Attenuation tank using polystorm-r geomodular units

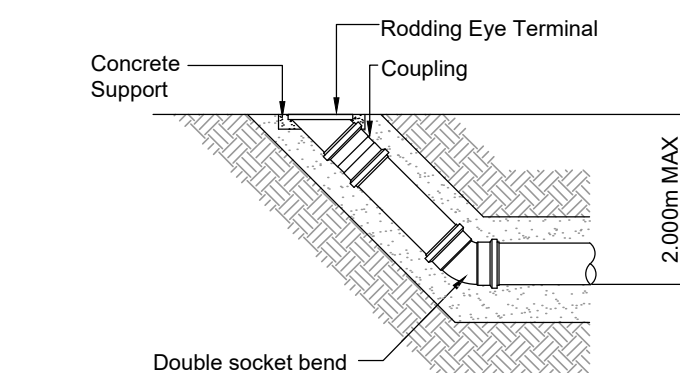
2. Please provide confirmation from our tree officer confirming that the tank is outside the existing and future root protection zones - Tree officer copied in.

14. Provide manhole as close to the tank as possible on incoming pipe and provided the vented cover at this location rather than the one shown at S5. Manhole to also include a sump. Show ventilation link pipe on plan. Also alter construction details to suit this arrangement - Done

20. Geosynthetic encapsulating polystorm unit – provide technical brochure extract detailing the tanking spec - Attached.
21. Add general note regarding manhole cover grades ie. grade and use - Done

Typical fin drain outlet from porous surfaces

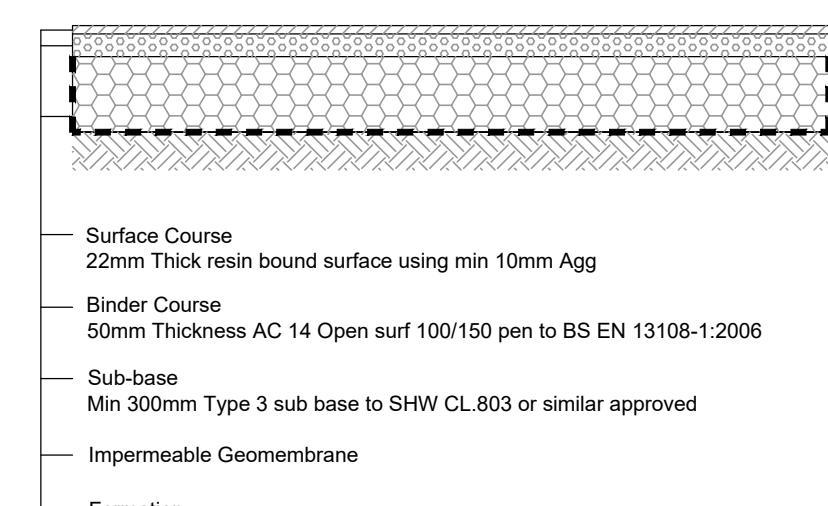
25. Driveways are falling towards the properties. Whilst the sub base water is being collected by fin drains, additional measures need to be put in place to protect the property/garages should the permeable surface become blinded and ineffective. I would suggest a decent channel drain - Agreed. Channel drain added.

Oblique Junction detail 100Ø - 100Ø

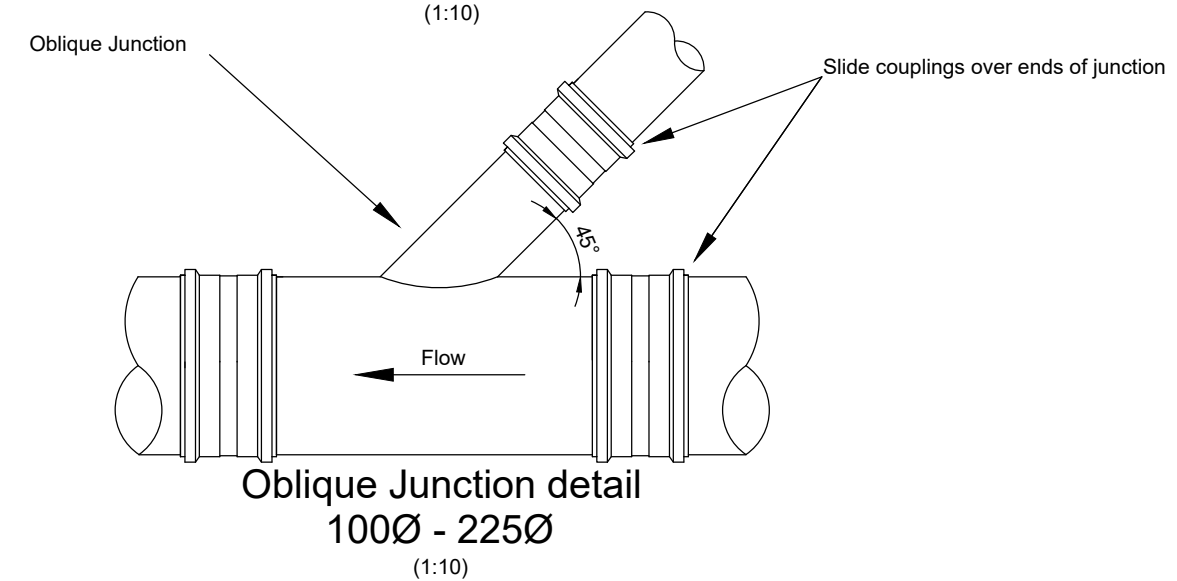
5. Provide backdrop construction detail - Done
6. Add suitable note 'all connections not to manholes to connect via oblique junctions as per your construction details'. - Added
